From: Anita Gardner
Sent: 07 September 2018 09:19
To: Planning.Responses
Subject: FW: Representation on: AB/36/18/PL at Blastreat Limited & adj Greenhurst

Demolition of existing buildings & erection of a block of 46 No. sheltered apartments for the elderly (comprising 22 x one bedroom apartments & 24 x two bedroom apartments age restricted to 60 years and over), with associated access electric buggy/cycle stores & refuse bin store & 32 No. parking spaces. Resubmission of AB/77/17/PL. This application affects the character and appearance of Arundel Conservation Area
Blastreat Limited & adj Greenhurst Fitzalan Road Arundel

Thank you for your internet comments made on 3rd September 2018 which has been recorded as **'an objection'** with the comments as follows:

Figure 30: South west elevation, towards Fitzalan Road and sections. Source: Renaissance Retirement Ltd (2018).

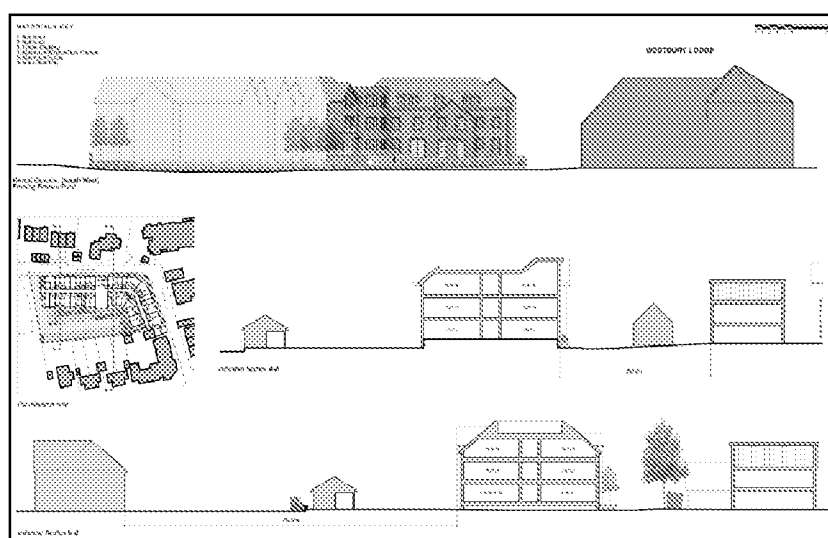
5) The Council objects on the grounds that the development would cause considerable harm to the appearance of the street scene along Fitzalan Road as it comprises a bulky uncompromising three storey continuous mass of building that would extend along almost the full extent of, and be set in proximity to, the narrow road frontage of the site where it would dominate and tower above other more discreet and domestic sized buildings that extend further along Fitzalan Road

View 01 proposed

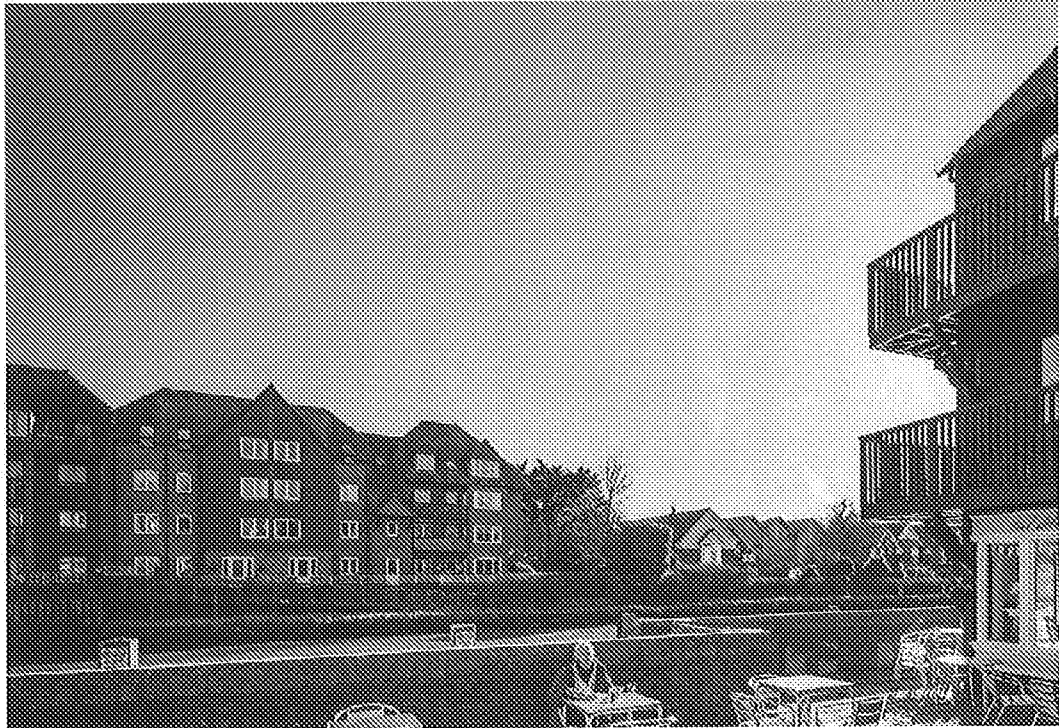
7) The poorly designed development would be prominently located in the forefront and against the backcloth of, the ancient, historic town of Arundel where it would dominate and appear incongruous in views from the bypass and footpaths and detract from the views of
